Application for Planning Permission

Development: Hand car wash facility including awning and portable cabin. This application is in CIL Zone 3 (Zero Rated) as other development.
Location: Highdown Nursery Littlehampton Road Ferring BN12 6PG

Hand Car wash
Planning Application
Location Plan

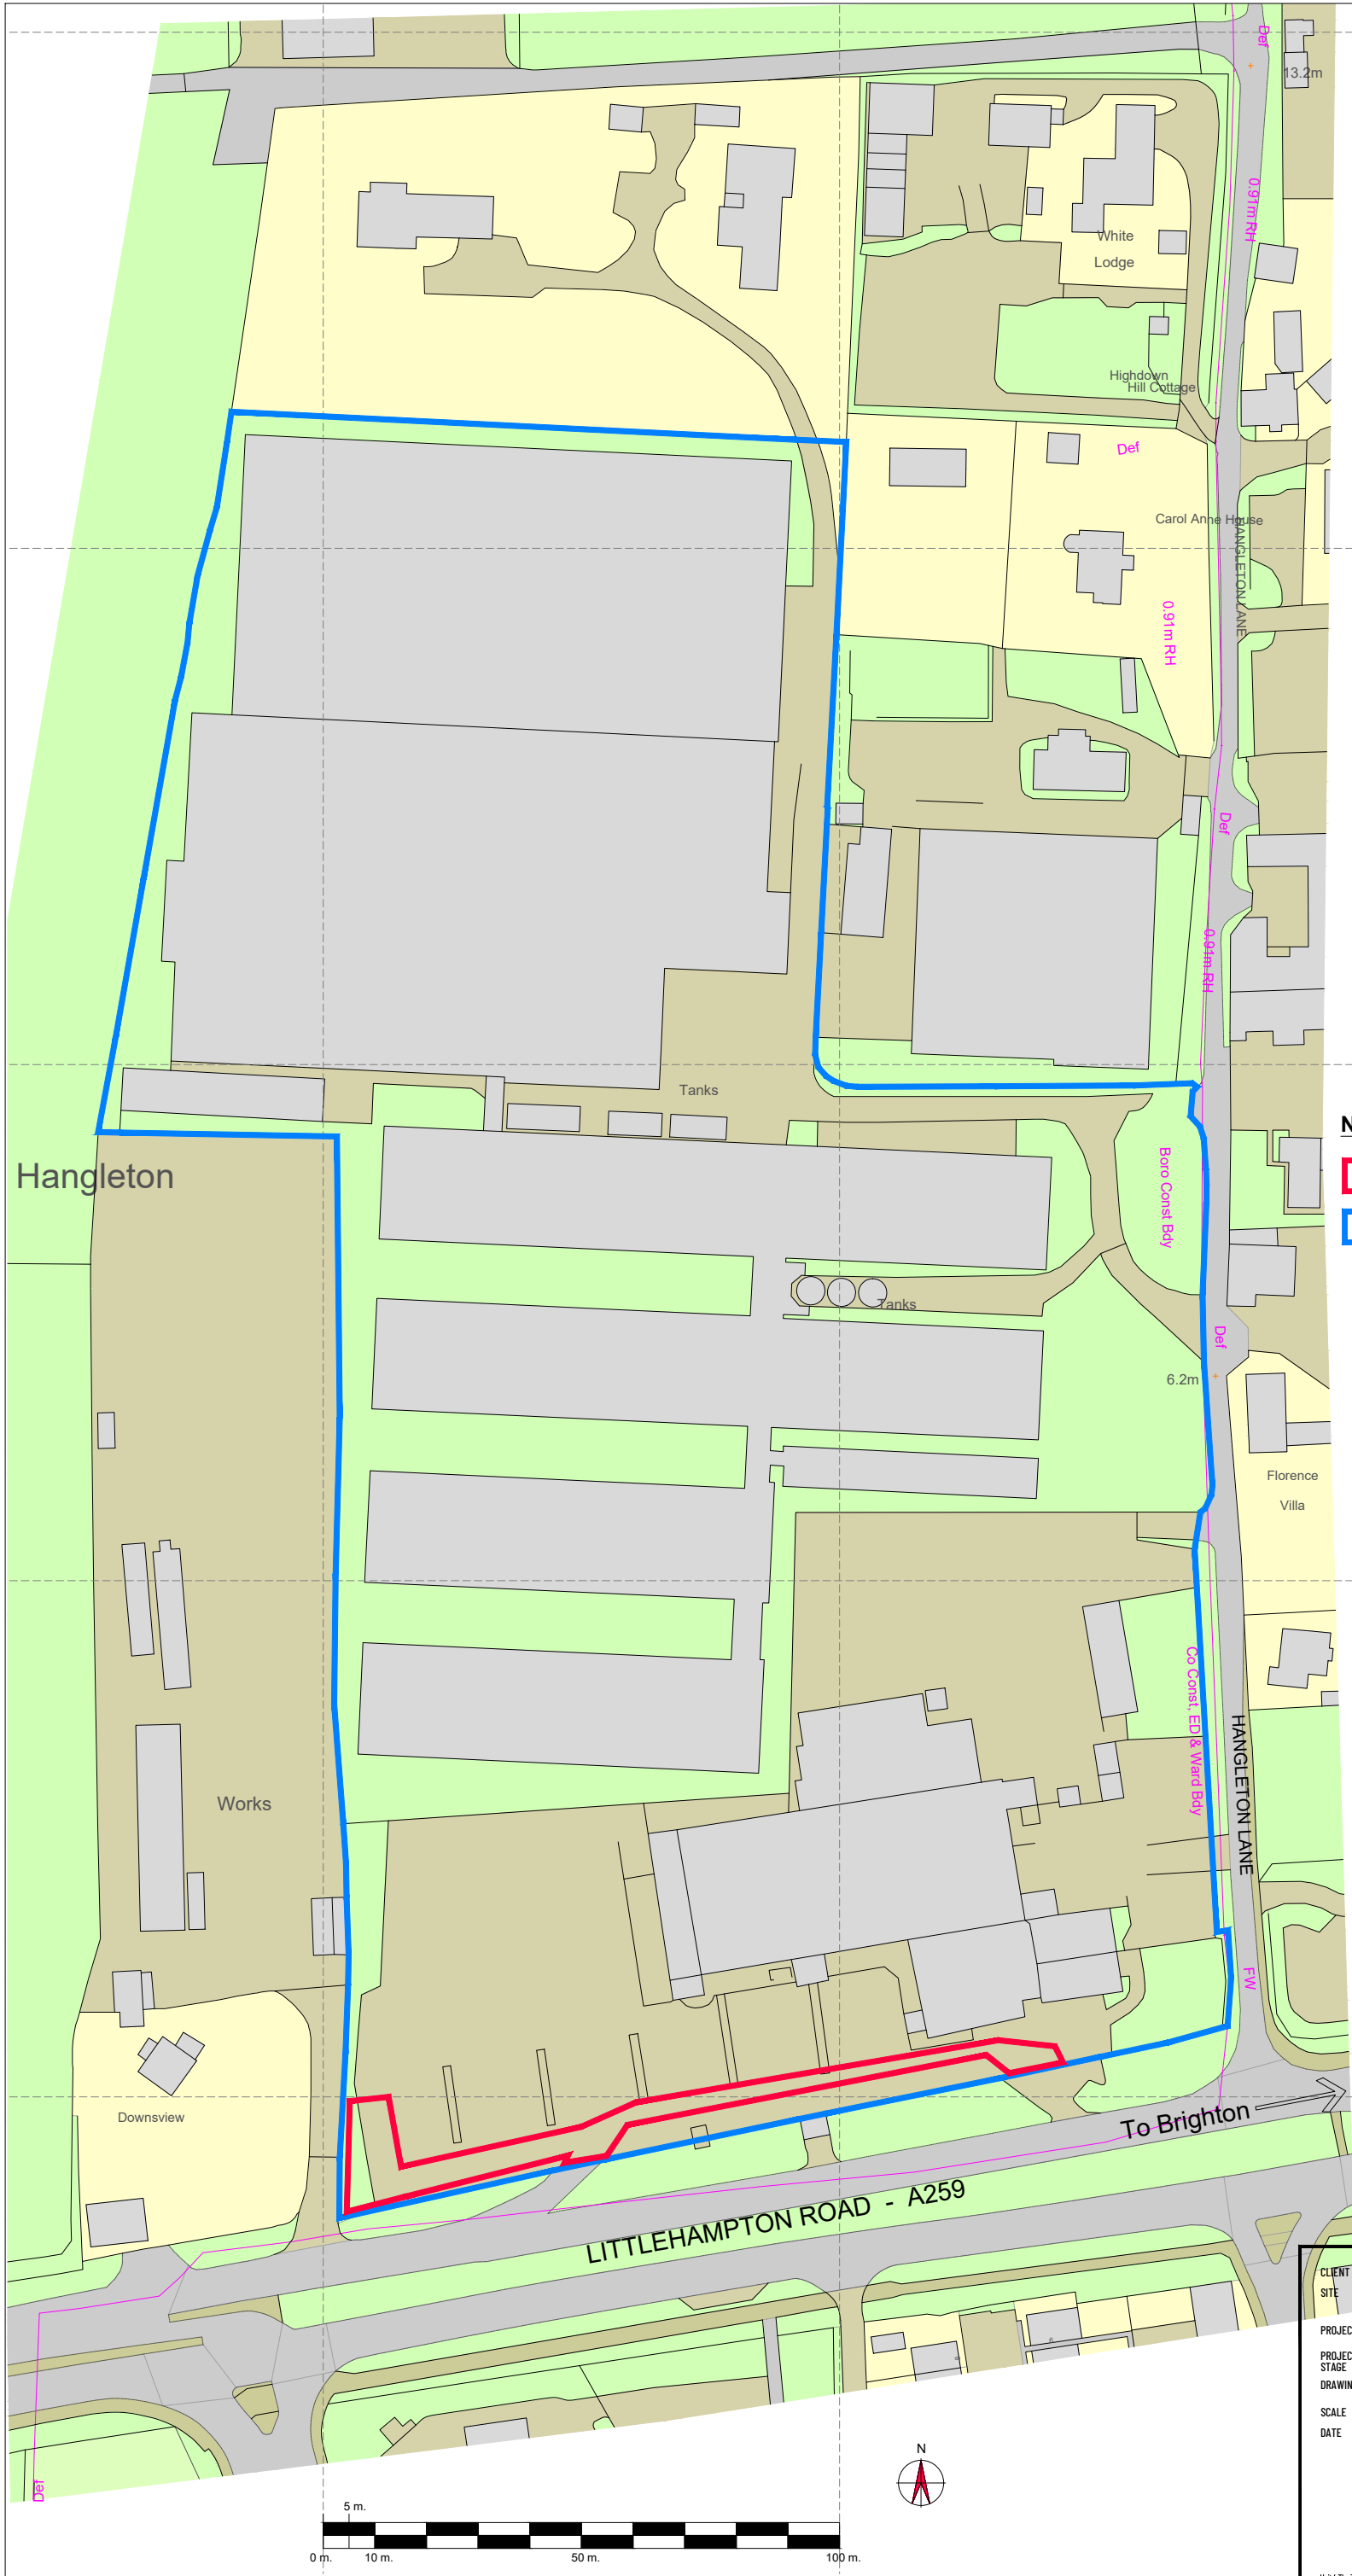
Please include the access to the site within the red edge.
